From: [Downes, Scott G \(DFW\)](#)
To: [Jeremiah Cromie](#)
Cc: [Torrey, Elizabeth M \(DFW\)](#)
Subject: RE: RU-22-00005 Kostenich - Notice of Application WDFW Comments
Date: Monday, November 28, 2022 9:37:11 AM

RE: RU-22-00005 Kostanich

TO: All Staff
FROM: Public Works Plan Review Team
DATE: December 12, 2022
SUBJECT: RU-22-00005 Kostanich

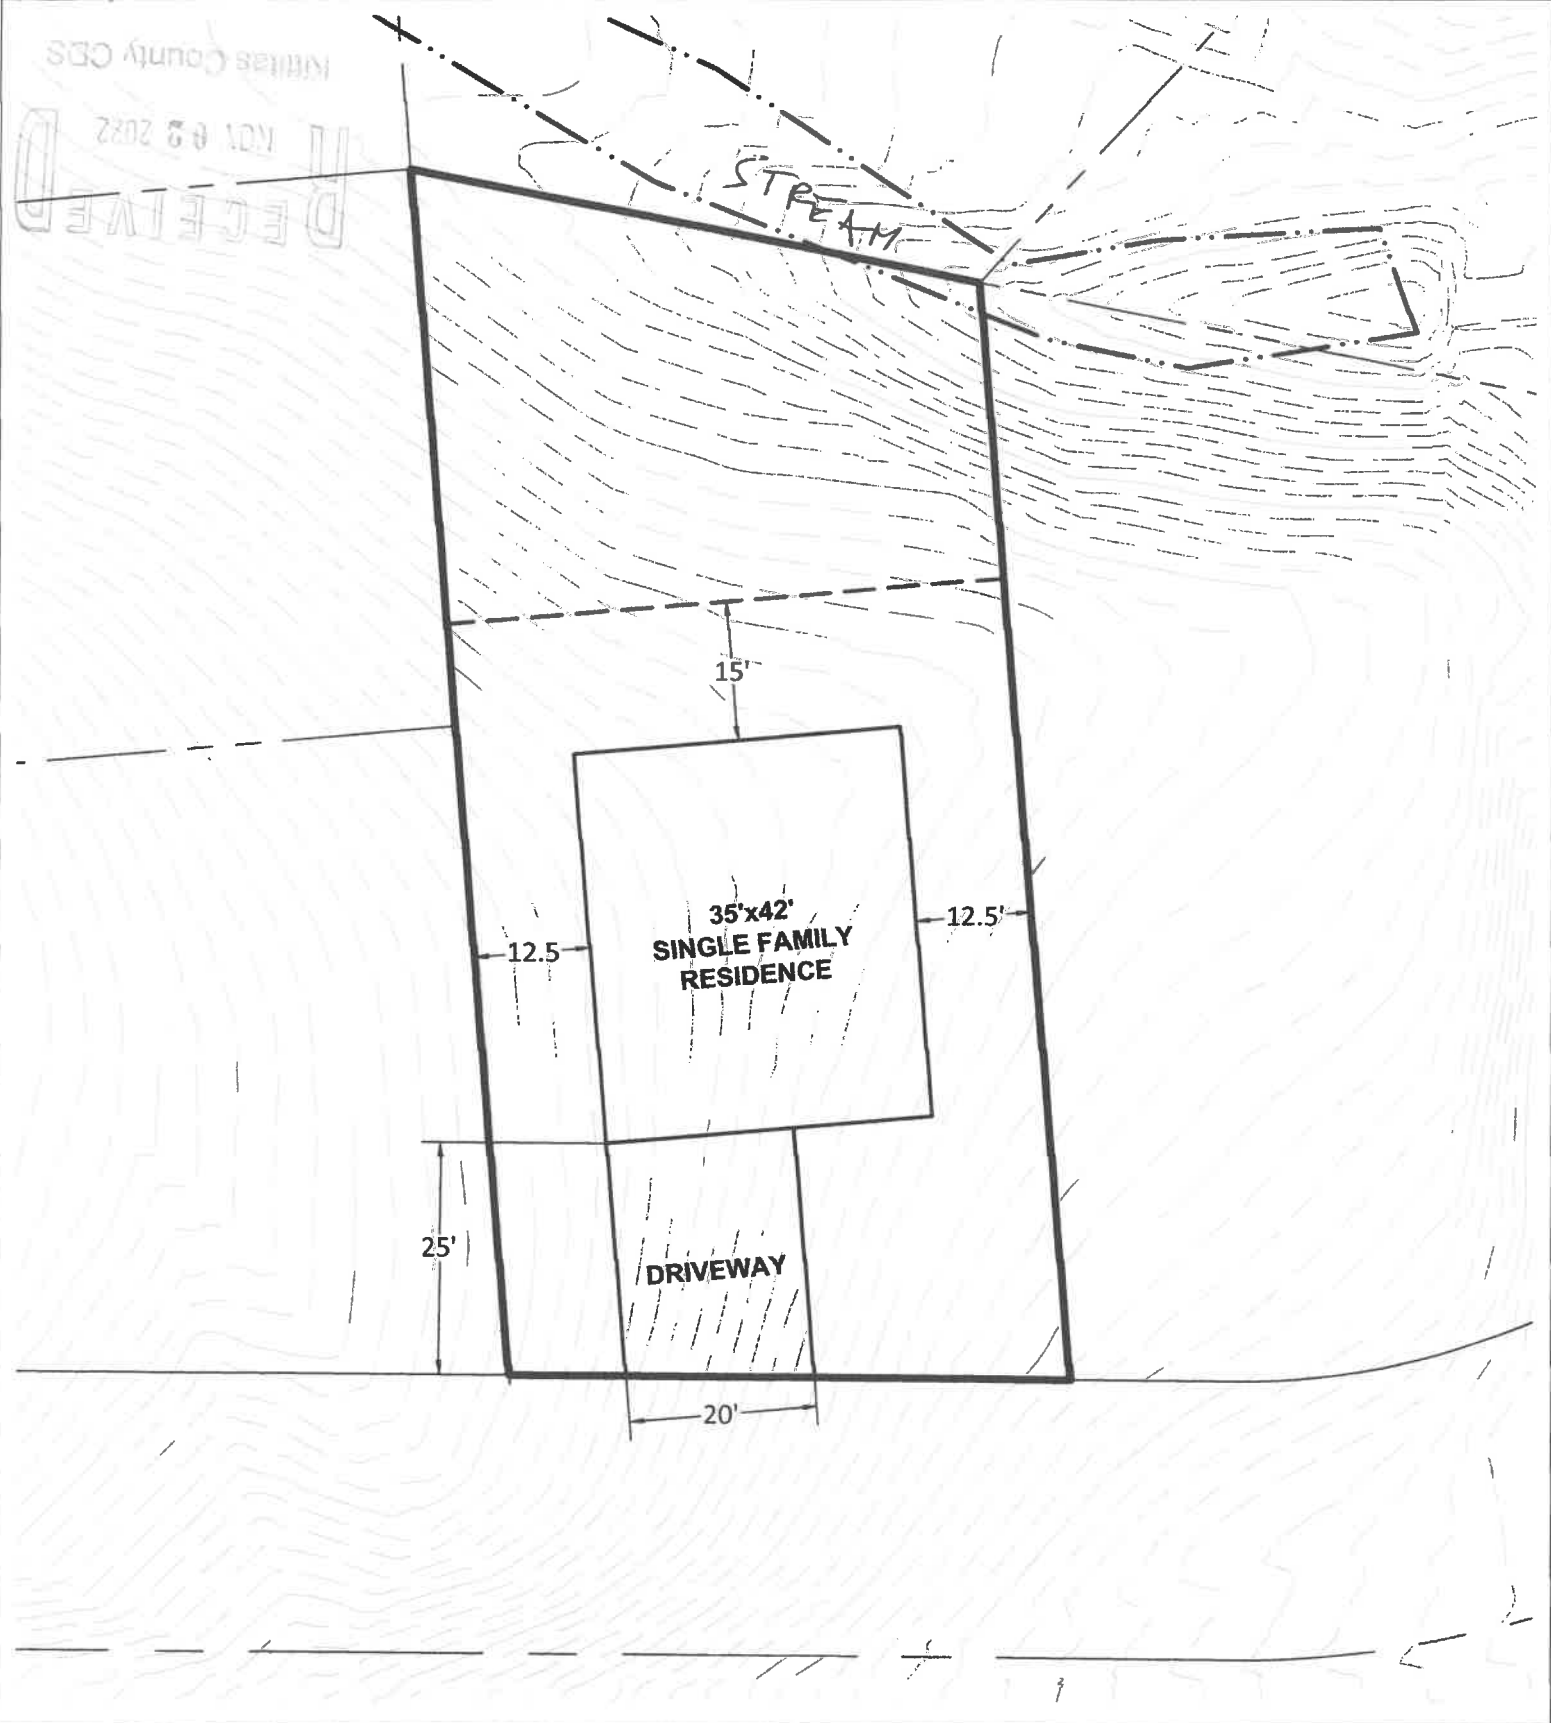
1. The applicant does not show on his site plan the distance to the stream edge to allow for comment on how far proposed setbacks from the creek would be. WDFW would like to see this distance prior to any approval and before the comment deadline in case we may need to make further comment.
2. The applicant should be submitting a mitigation plan for potential impacts to the riparian area from encroachment due to the building. That mitigation plan should include strategies to offset any loss of riparian function from vegetation (trees, shrubs) lost from the clearing. Once a mitigation plan is prepared, WDFW would like to review and comment and if necessary meet on site to discuss prior to approval of a mitigation plan. WDFW requests that this mitigation plan be a condition of an approval.

Thank you for the clarification. WDFW does have significant concern with building so close to a Type F (fish habitat). WDFW would not be in support of approving this application without a mitigation plan that ensures there is no net loss of riparian function and habitat. WDFW does not agree with the CAO report that placing a single family residence here (within 50 foot of a Type F creek) will have no negative impact. Further at this site, across the creek, there is also riparian impacts planned (that have been mitigated) through the Ski Acres proposed development. While we appreciate that they have kept the home small, could their site plan include reduction in driveway setback so that they could setback further from the creek.

The site plan is scaled and scaled correctly. I did a quick measure and it looks like the nearest point of the proposed residence is 44 feet from the stream (see attached pdf). That should help with your first comment and any subsequent comments that result.
